**COMMUNITY SERVICES DEPARTMENT**  
PARK OPERATIONS ~ PLANNING ~ CSU EXTENSION ~ COMMUNITY OUTREACH  
ENVIRONMENTAL SERVICES ~ VETERANS SERVICES ~ RECREATION/CULTURAL SERVICES

March 5, 2020

**Subject: Bent Grass Residential Filing No. 2 Final Plat, Review #2 (SF-19-014)**

LOCATED IN THE NORTHWEST QUARTER AND SOUTHWEST QUARTER OF  
SECTION 1 T13S R65W OF THE 6TH PRINCIPAL MERIDIAN  
COUNTY OF EL PASO, STATE OF COLORADO  
PROPOSED LOTS, TRACTS AND EASEMENTS MAP

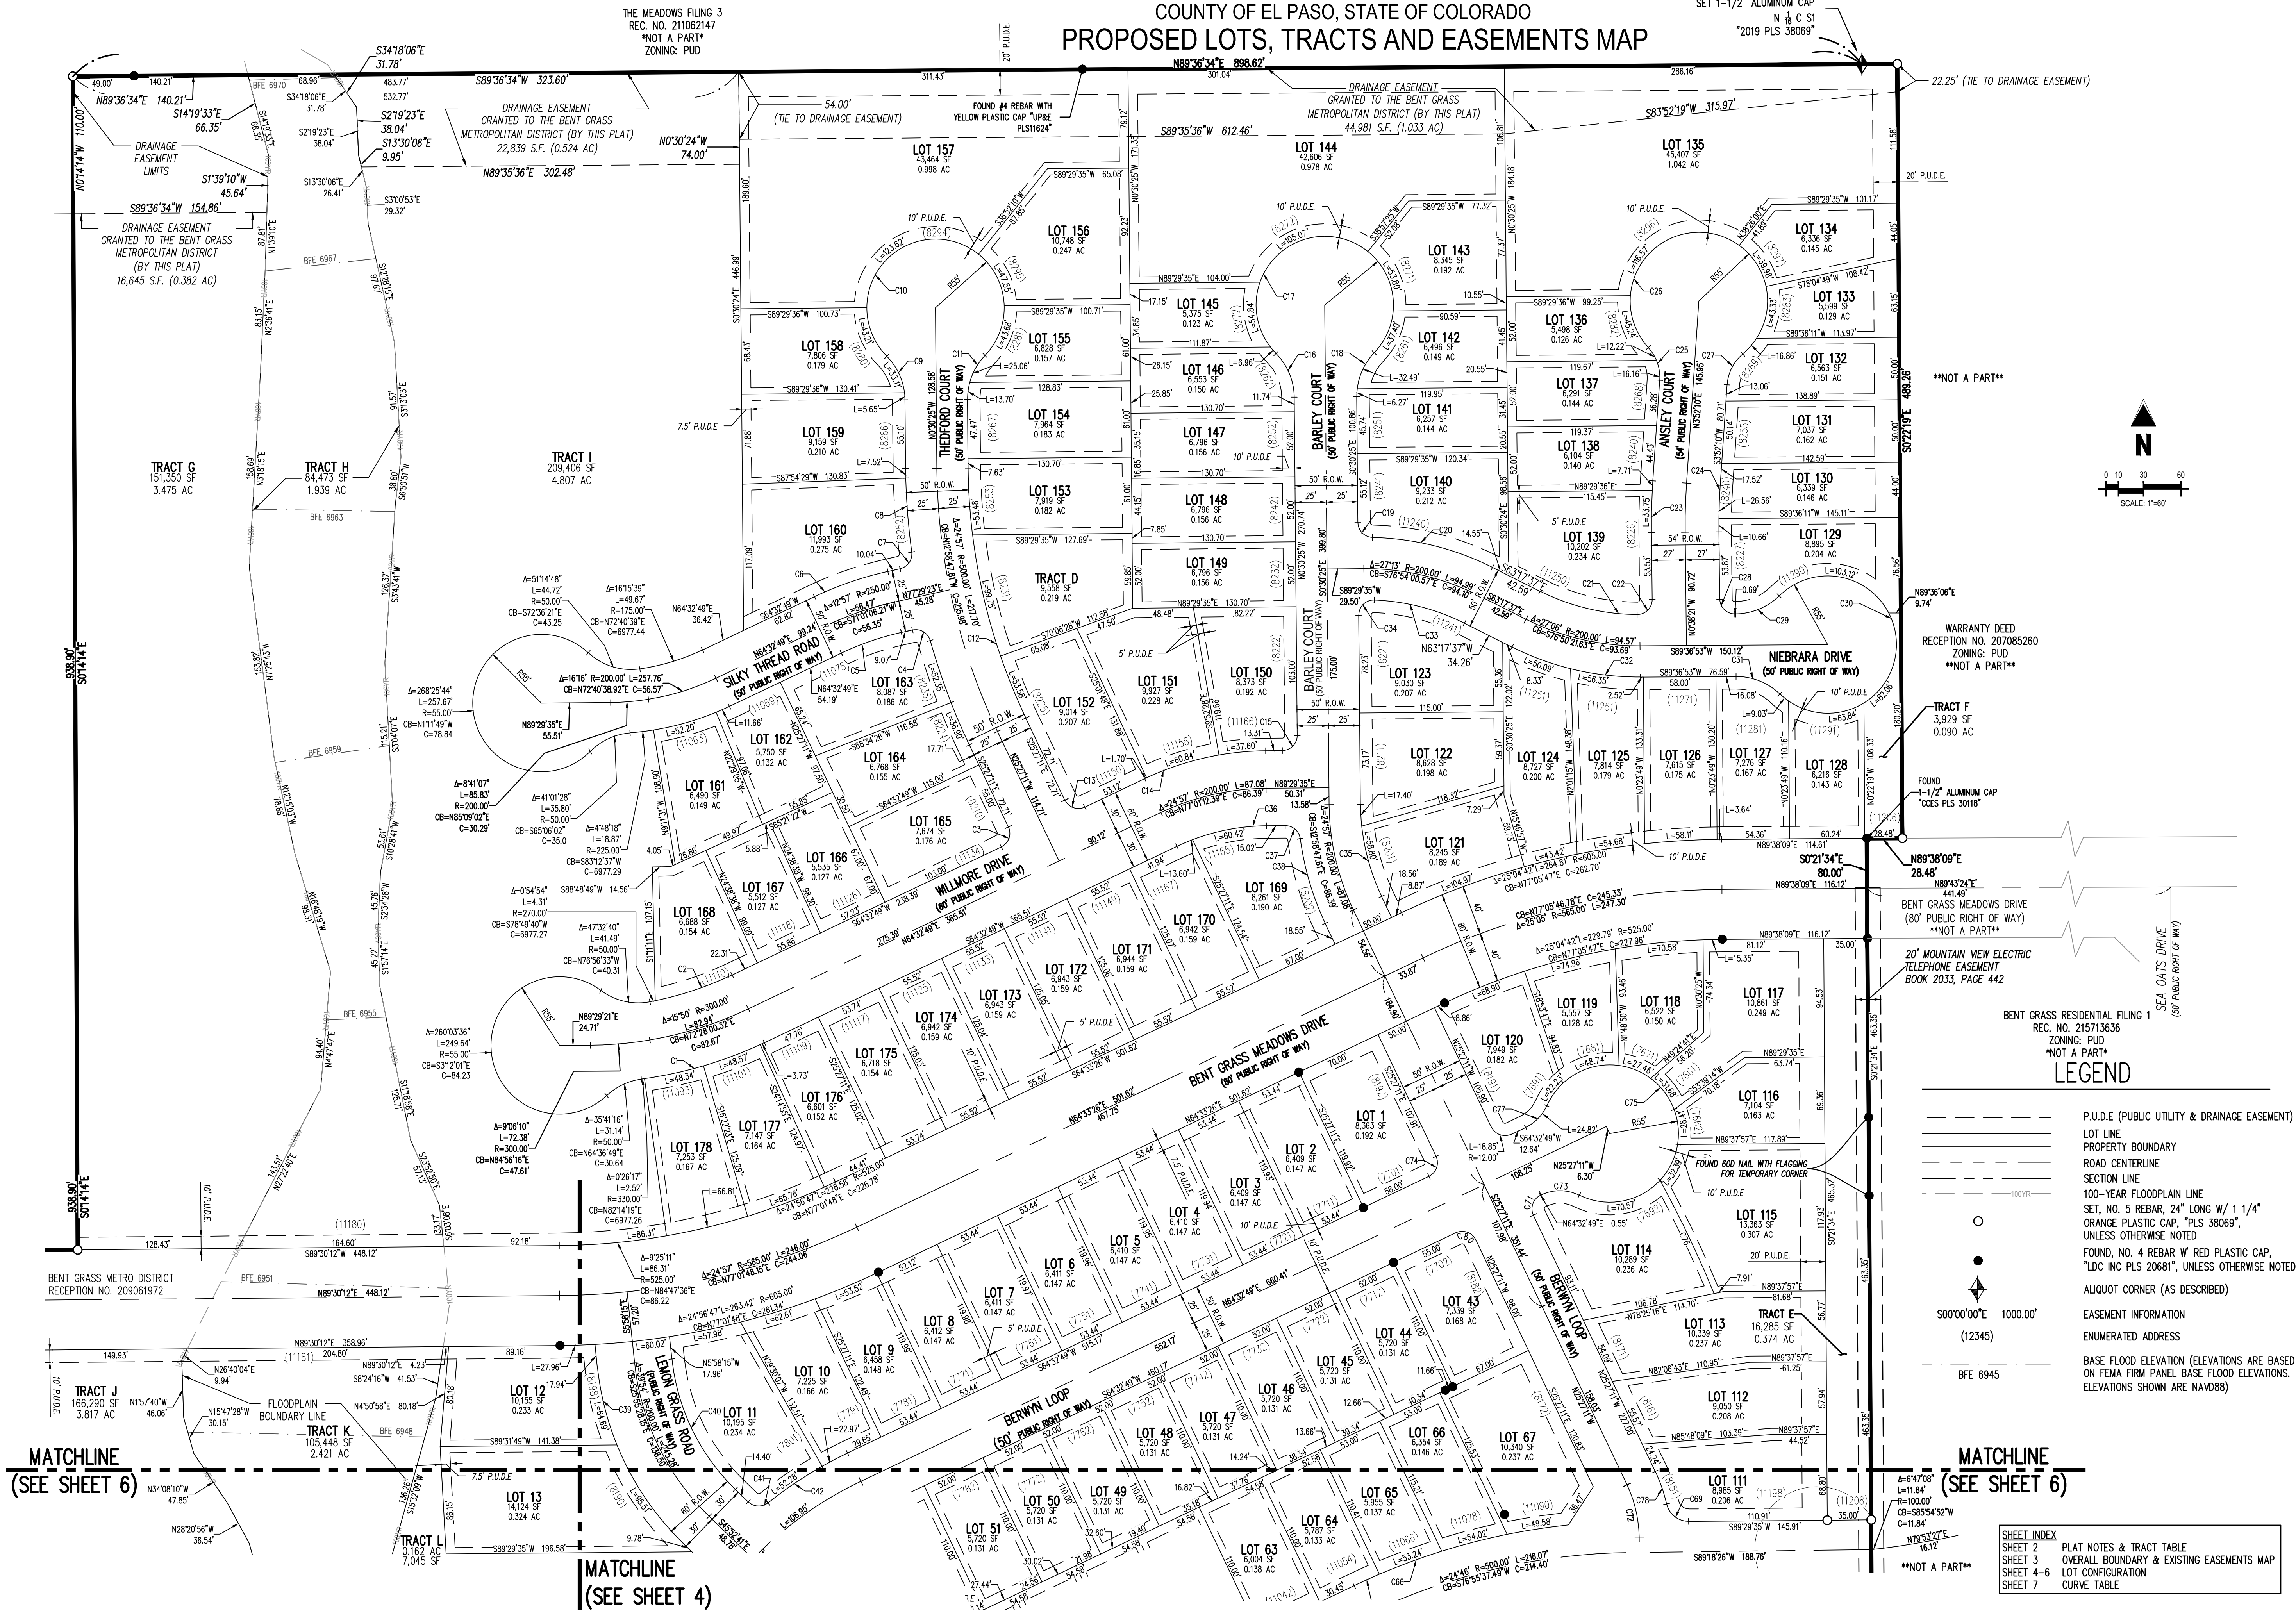
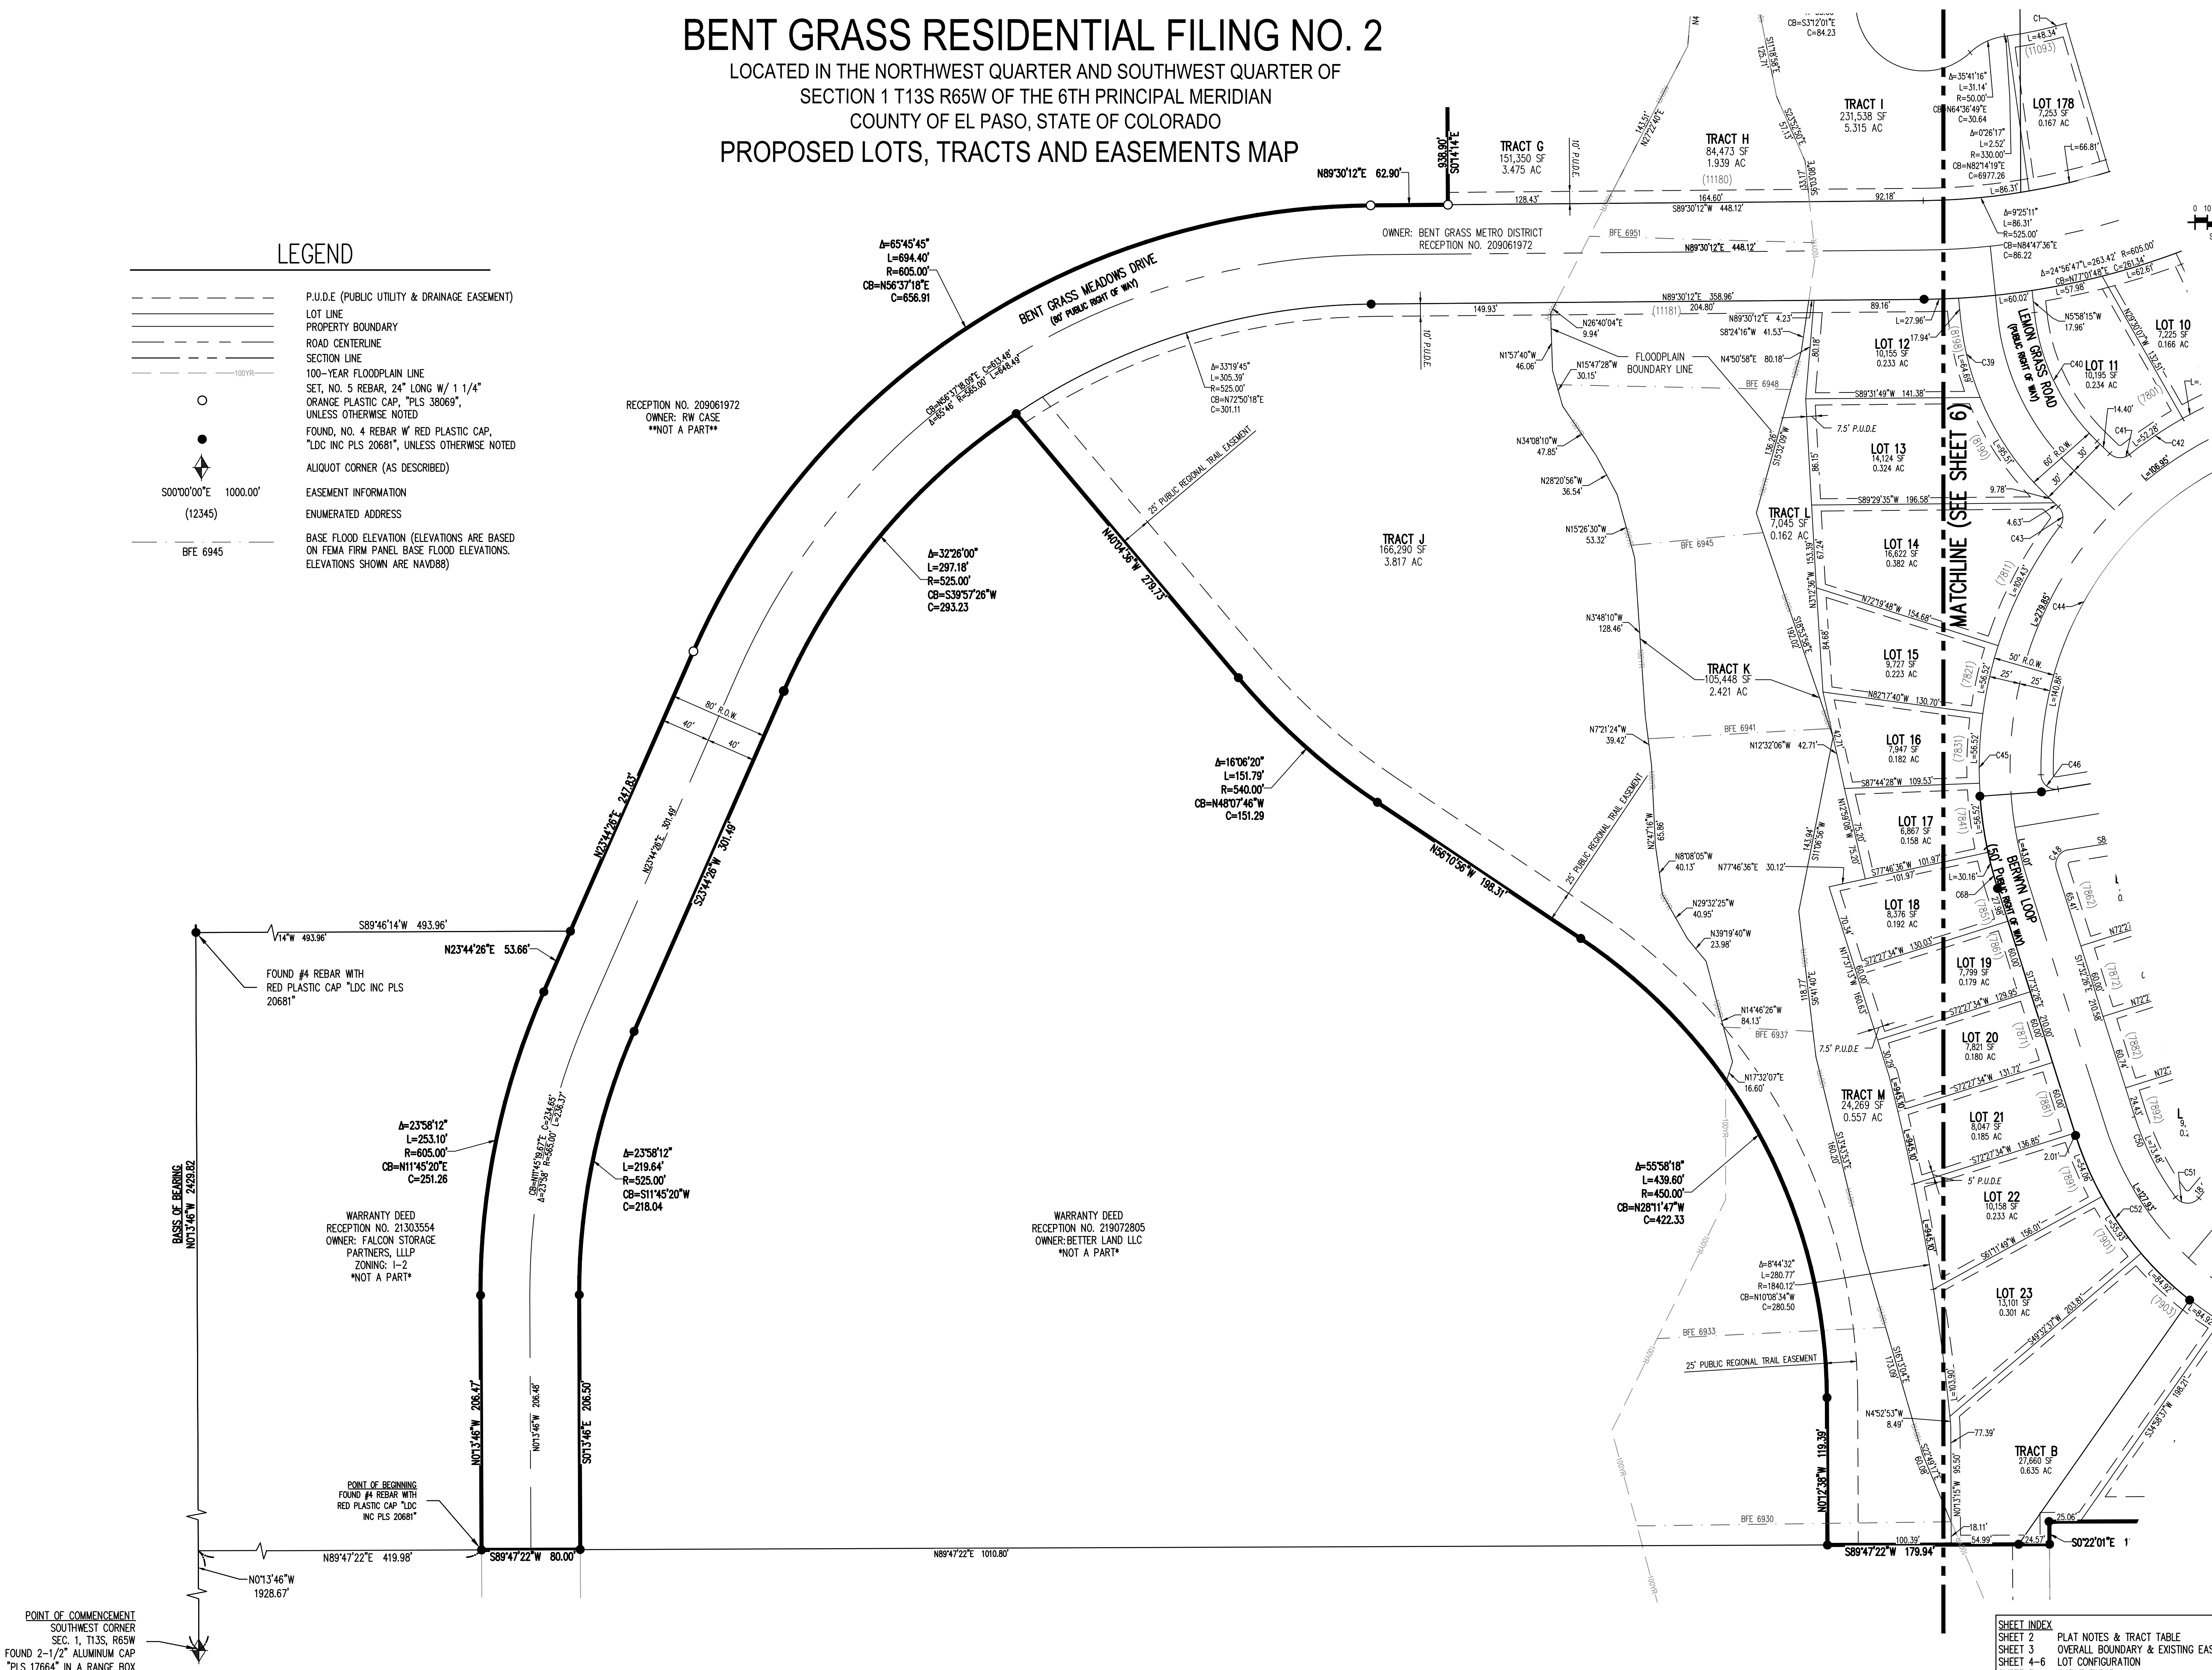
Due to the fact that the trail easement itself is located within the bounds of Bent Grass Residential Filing No. 2, the trail easement must be dedicated to El Paso County as a term of this Final Plat, as easement dedications occur on a per-plat basis. The applicant must show the trail easement on the Bent Grass Residential Filing No. 2 Final Plat and dedicate to El Paso County a 25-foot trail easement through Tracts J and K that allows for public access, as well as construction and maintenance of the Woodmen Hills Secondary Regional Trail. This dedication must take place prior to the recording of the Final Plat.
